Town & Country Planning Act 1990 (as amended) s211 Notice

Prior Notification of Work to Tree(s) in a Conservation Area

Development: 1 No. Oak tree - Reduce crown height by 2.5, Crown thin by 20% and Crown lift to 2m above ground level within the East Street, Littlehampton Conservation area.
Location: 16 East Street Littlehampton

Sketch plan of tree for maintenance 16 East Street,
Littlehampton – Ref LU/153/22/TC

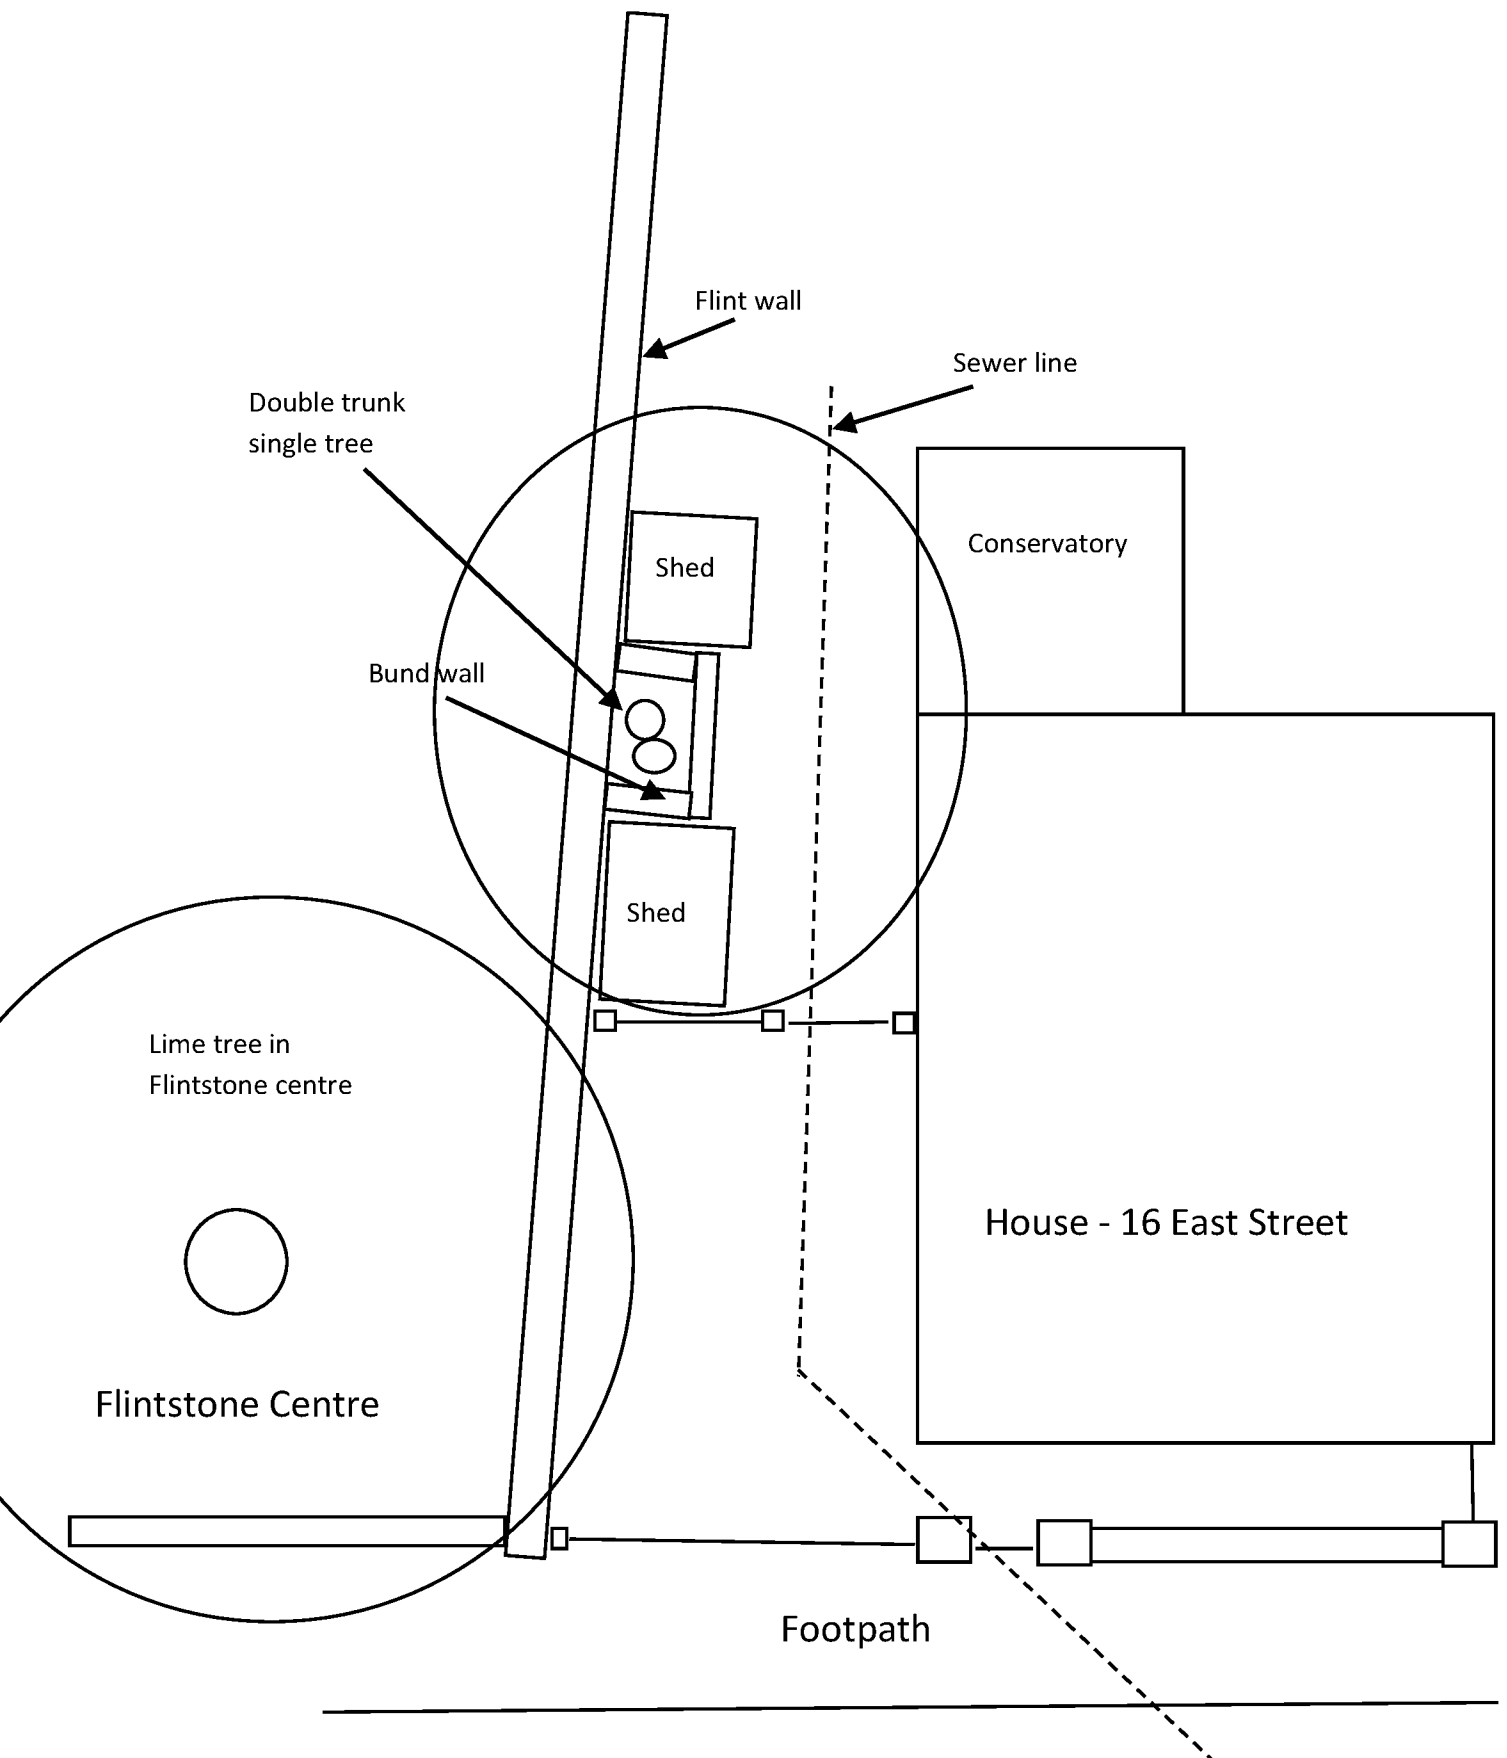
Please submit a sketch plan clearly showing the location of the tree. The plan should include road names and adjoining properties so that the location is very clear. A North point is also helpful.
